Re: Las Lomas Industrial Park (DRB 1002134)
Revised Las Lomas Conceptual Grading and Drainage Plan (D 16 / D 2)

Accompanying this letter is a revised conceptual grading and drainage plan for the proposed Las Lomas Industrial Park. Following are responses to your comment letter dated December 29, 2004:

A03JOBS\A3102VNIP\A3102ad.dwg 1-18-05 DER TAS

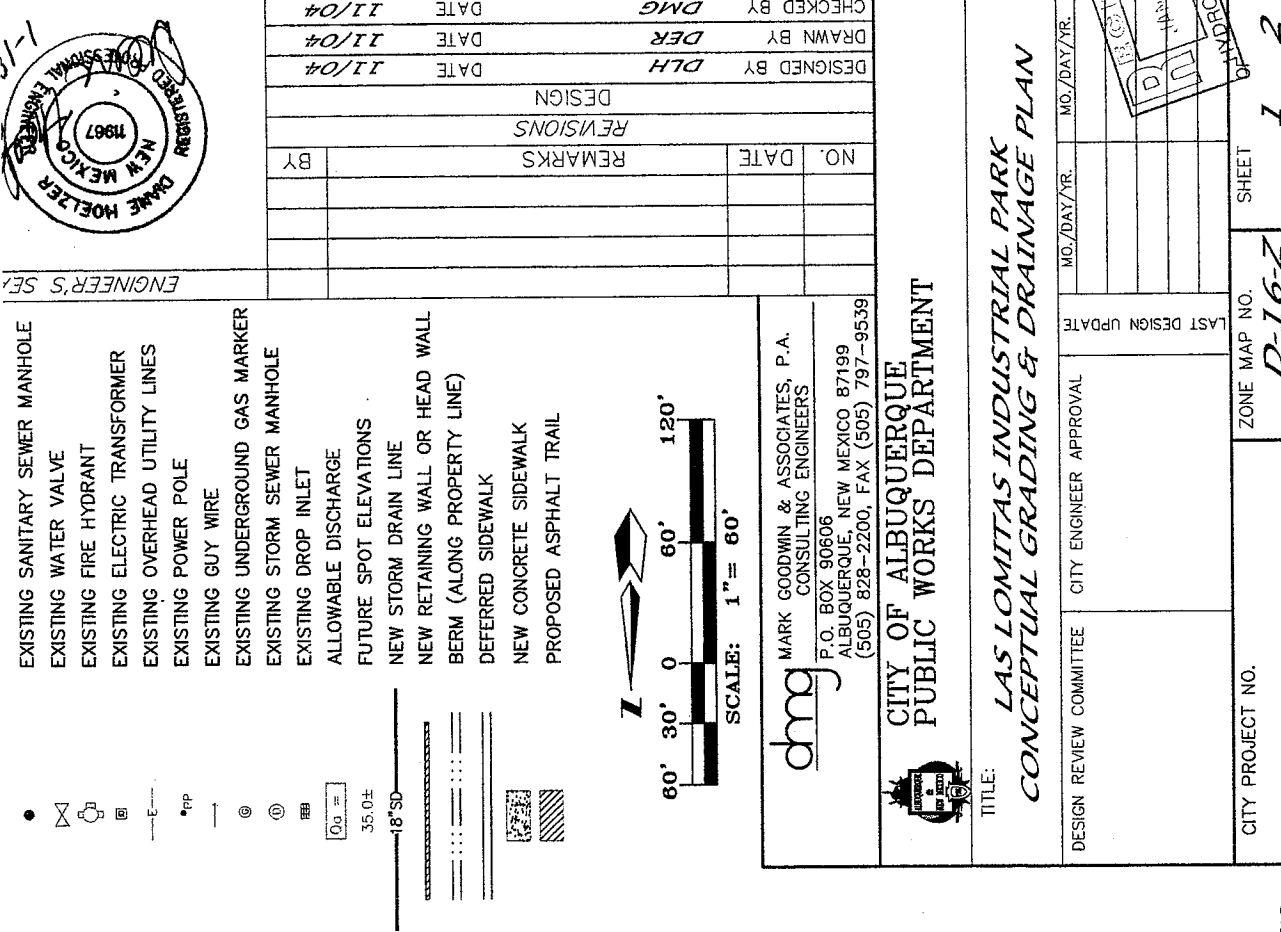
1. The westernmost berm has been placed outside of the right-of-way allowing for a maximum 2 percent slope within the Las Lomas Drive R/W.
2. A drainage easement has been placed on Tract 5.
3. The project site will be massed graded as shown on the revised grading and drainage plan so there is no longer a need for an interim plan.
4. Tracts 3-5 will be graded so that runoff now flows into Las Lomas Drive and into the existing sump inlets. Tracts 1, 2 and 3 and Tract U-5 are restricted to 1.0 cfs each which should flush out far in advance of the North Pond runoff spill into the 18" storm outfall.
5. Please refer to the Appendix C Storm Sewer in the previously submitted November 19, 2004 drainage report. A preliminary storm sewer analysis was already done that shows the existing 48" RCP in Las Lomas Drive can adequately convey the peak 100 year runoff of 167 cfs.

6. *Please refer to Table 1: Summary of Hydrology in the November 19, 2004 drainage report. Tract T-4 (aka Tract T-4-A) shows a 100 year peak discharge of 101.84 cfs which was incorporated into the preliminary storm sewer analysis mentioned in #5.*
